Reference No:	2026/62/90591/W
Site Address:	4, Longley Road, Almondbury, Huddersfield, HD5 8JL
Description:	Alterations to convert garage into habitable space and erection of first floor front and side extension and single storey rear extension
Recommending Officer:	Joshua Merriman

DECISION – FULL CONDITIONAL PERMISSION

Officer Report – 2026/90591

1 PROPOSED PARKING PLAN
1 : 200

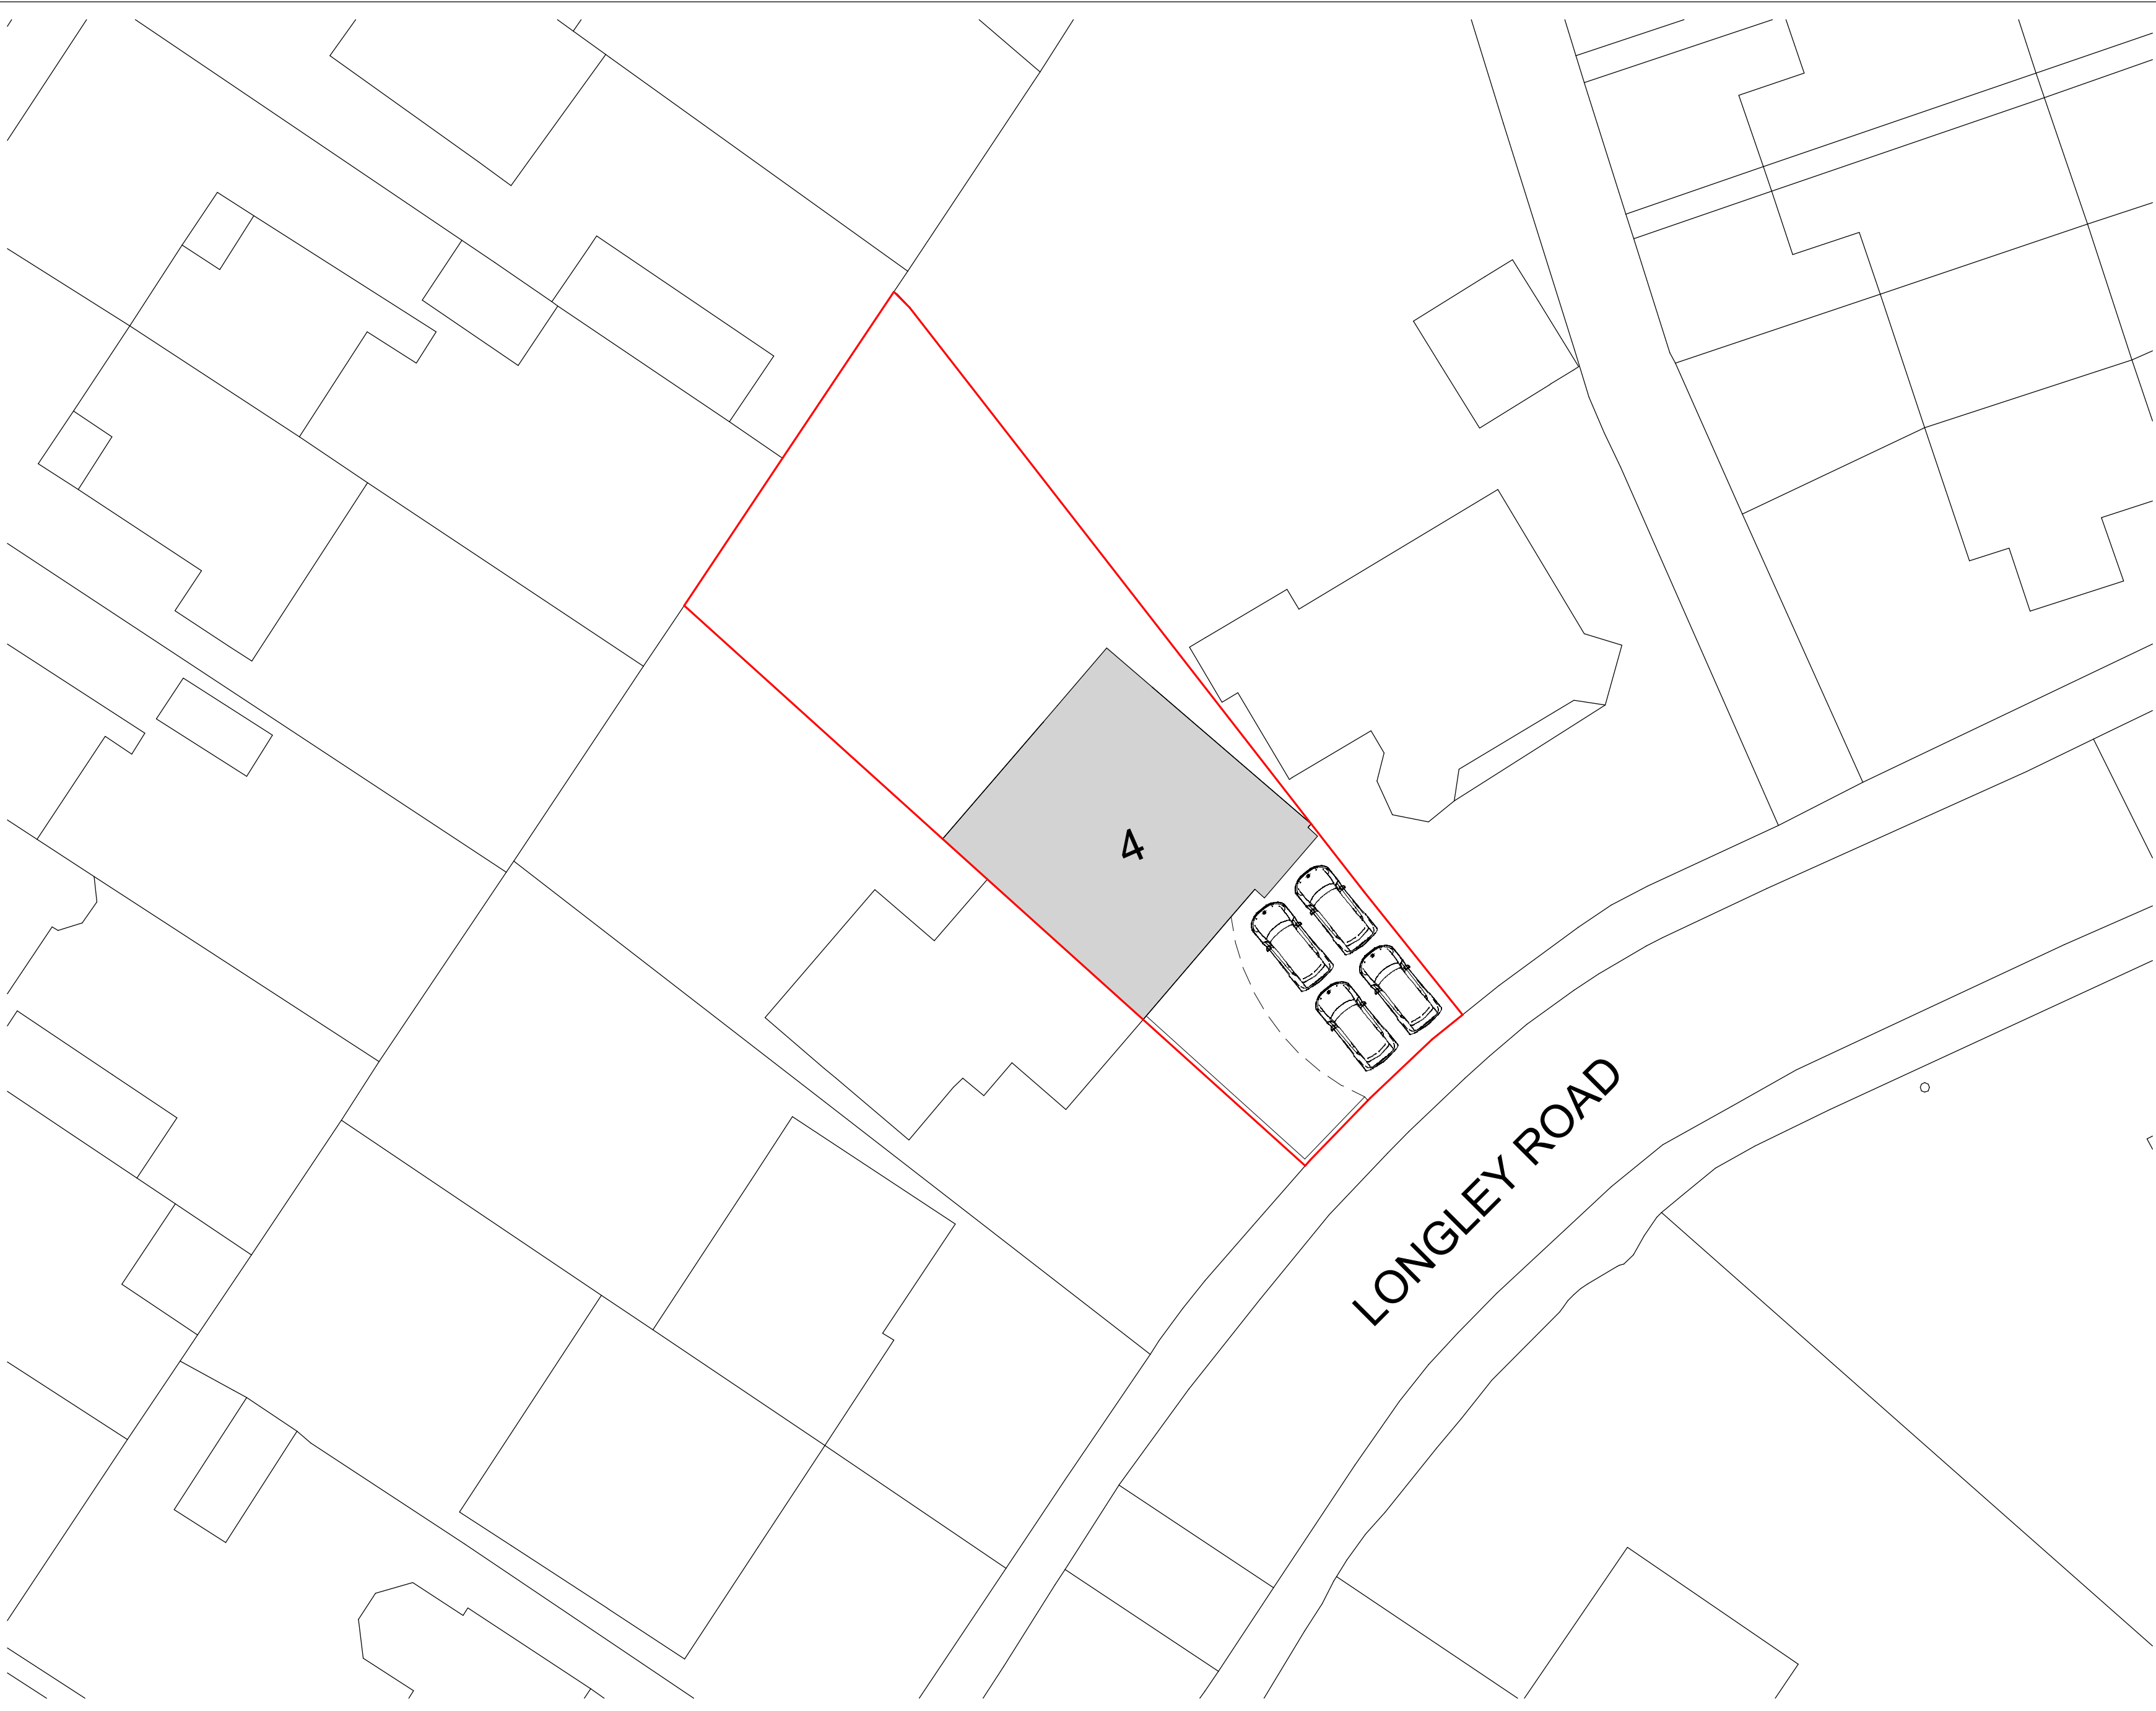
No amendments have been requested by Officers. However, officers requested the submission of a parking plan to ensure the property could maintain adequate off-street parking arrangements despite the intensification of the site.

The number of bedrooms in the property will increase from three to four as a result of the proposal, therefore, the required number of off-street parking spaces will increase to three at the application site. As the parking area on site will not be reduced in scale, and the plans submitted show it will remain adequate, it is considered that this is acceptable to remain. Furthermore, the proposal will have no significant impact on highway safety as the dwelling is set well back from the closest highway.
